From: Julia Davies [REDACTED]
Sent: 15 January 2019 17:34
To: Zac Denton
Subject: 13 Grand Avenue (LU/321/18/HH)

(Attached drawings P01b and P02a to be substituted for drawings P01a and P02 respectively)

Proposed Loft Conversion
at 13 Grand Avenue, Littlehampton
for Mr P Pedzinski & Ms P Marsh
Drawing P01b October 2018 Scale 1:100 @ A3
Planning Drawing - Plans and Elevations

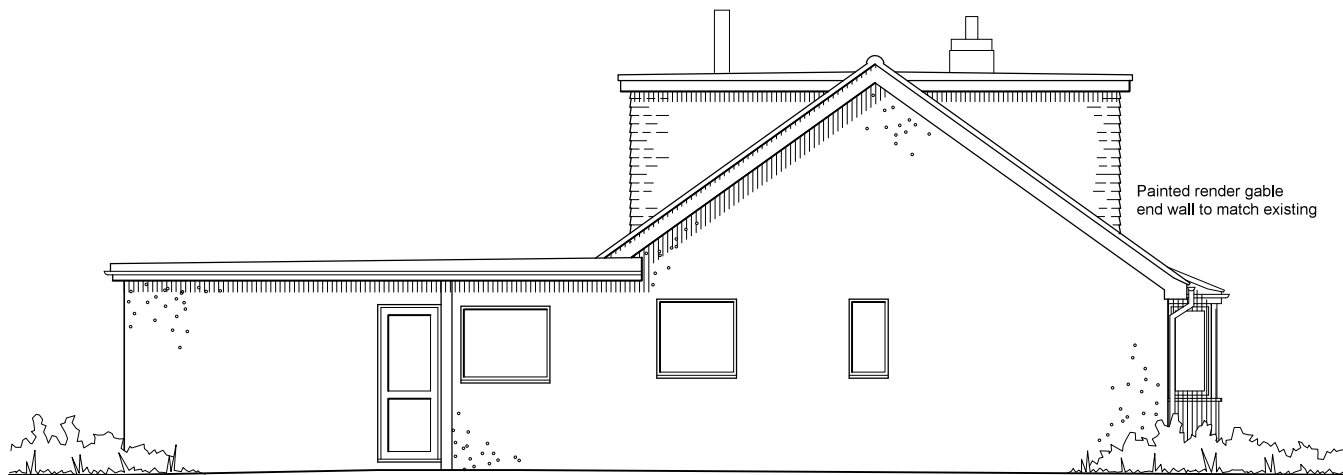
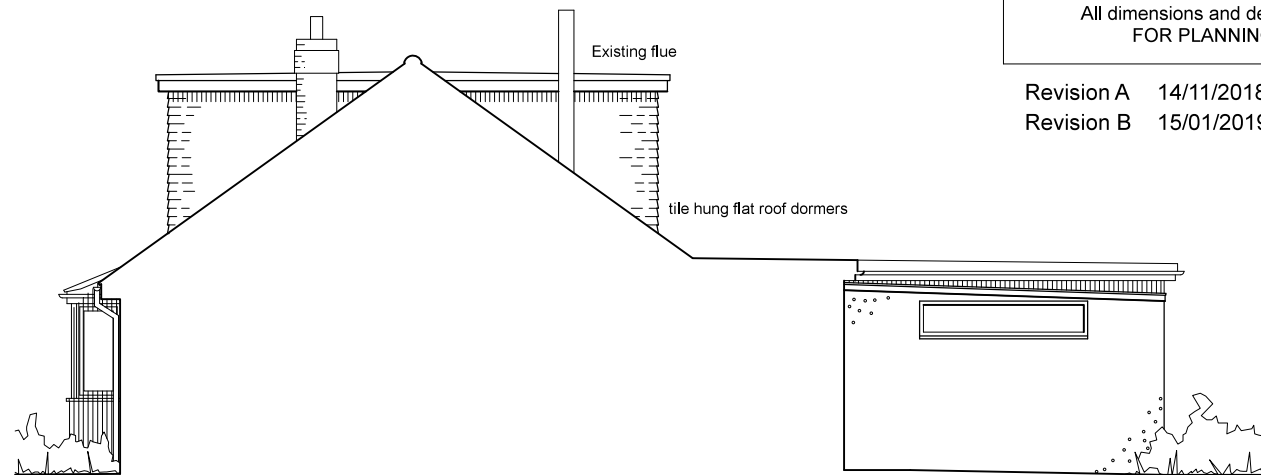
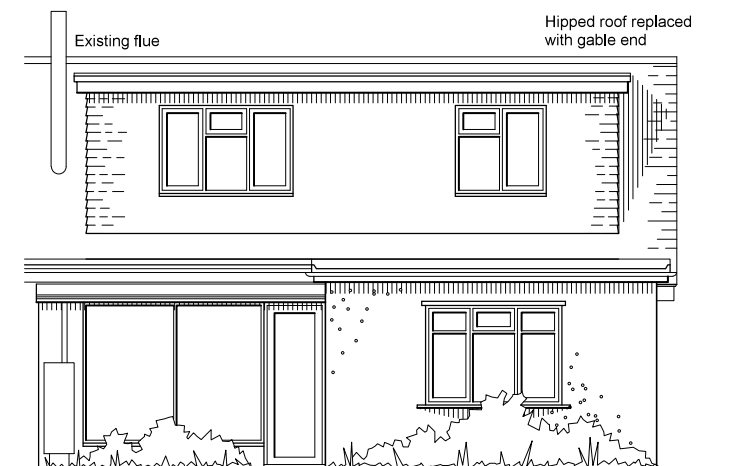
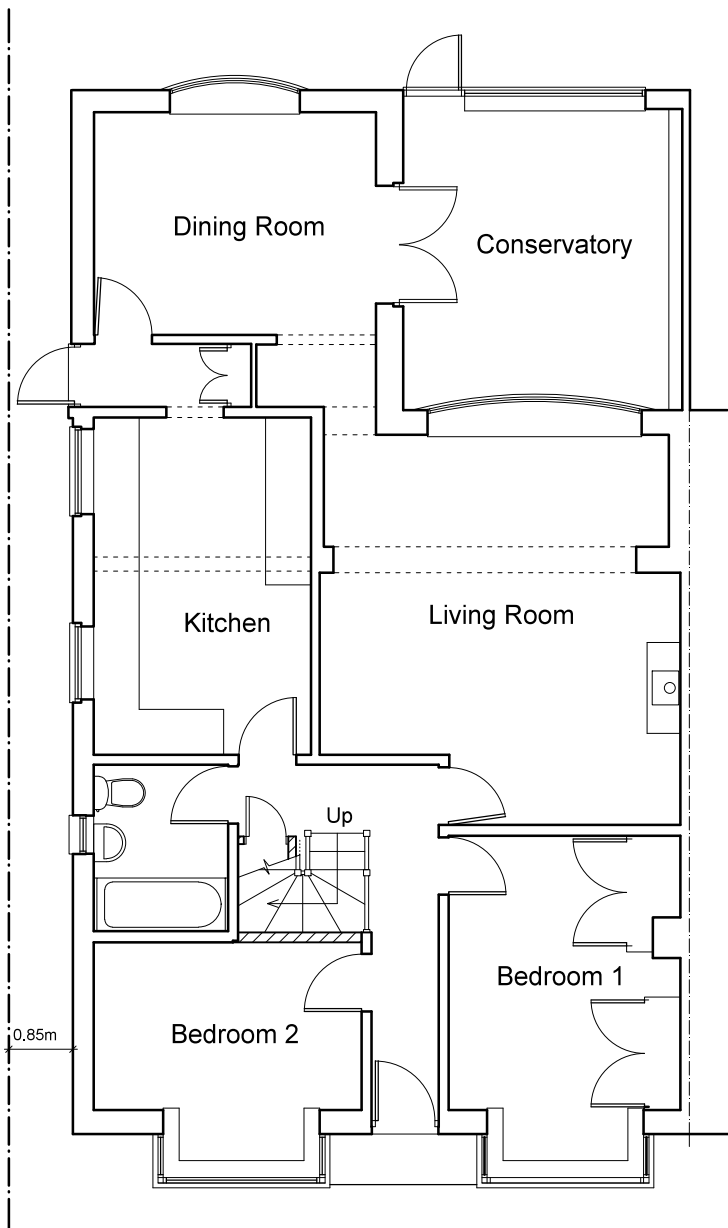
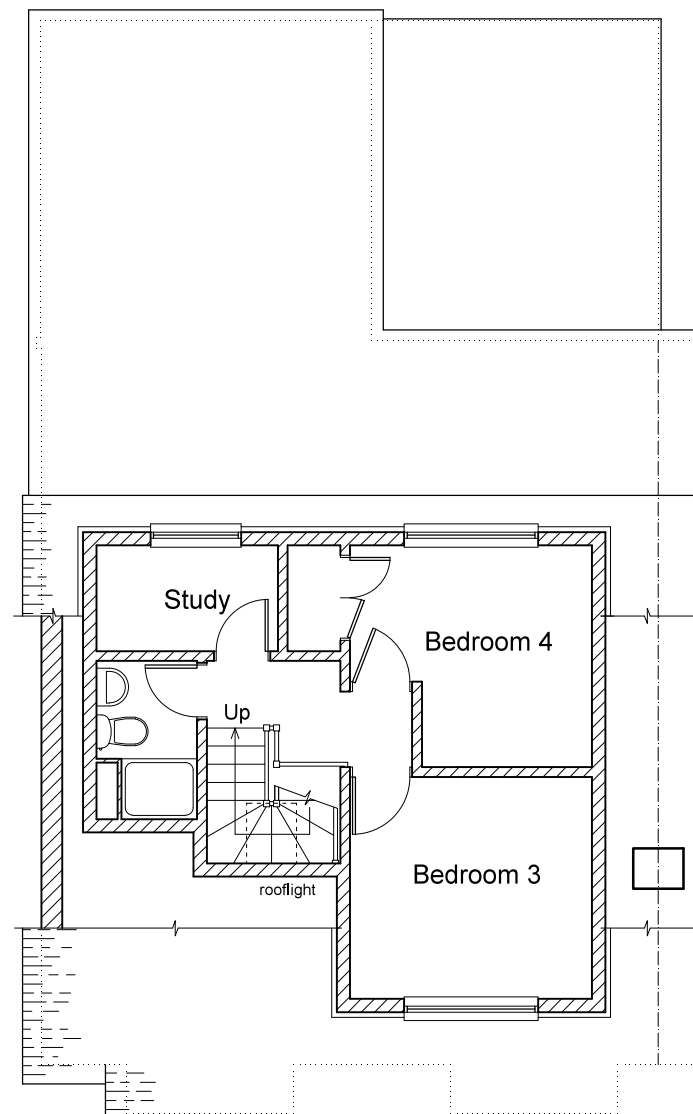
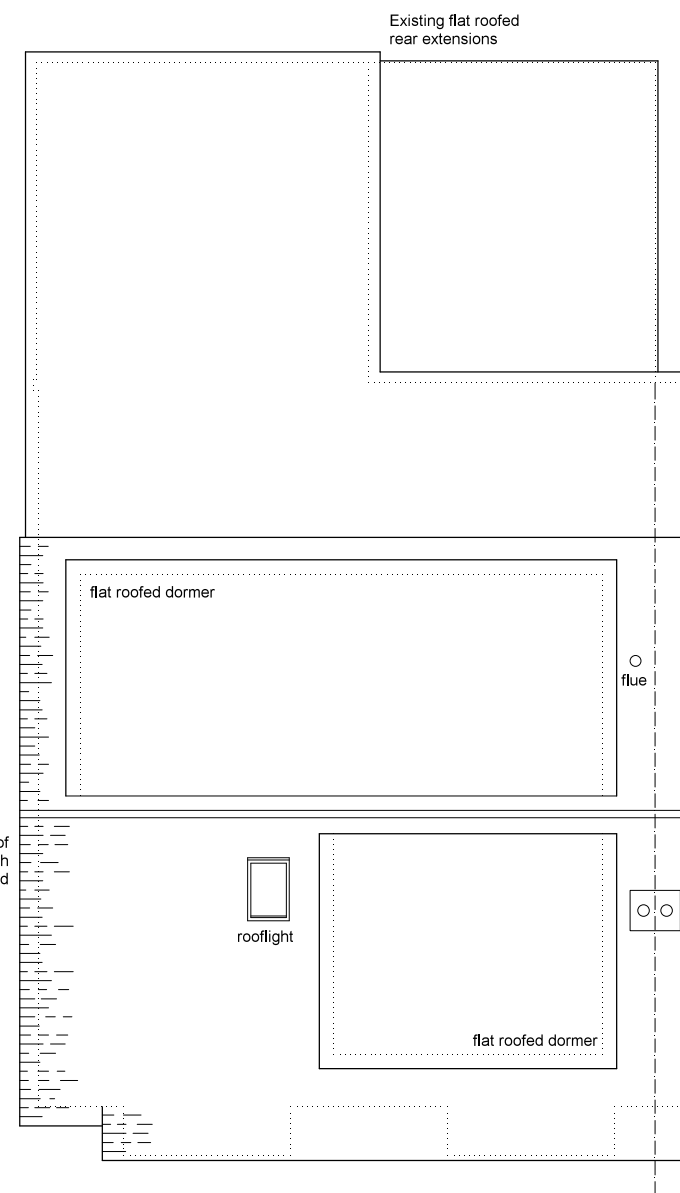
Please find attached a set of revised plans and elevations for the loft conversion. Whilst I appreciate your request for a reduction in width and depth of the rear dormer, it is not possible to achieve the accommodation that the owners require with such a significant loss of floor space.

In light of this, I have moved the rear wall of the dormer back 1.2 metres, so that it is no longer behind the rear wall of the original property. However I have maintained the width as originally proposed. The western wall is already set back from the party wall line; research of similar properties in the immediate area showed that there are other properties that have had a full width dormers approved for both the front and rear of the roof.
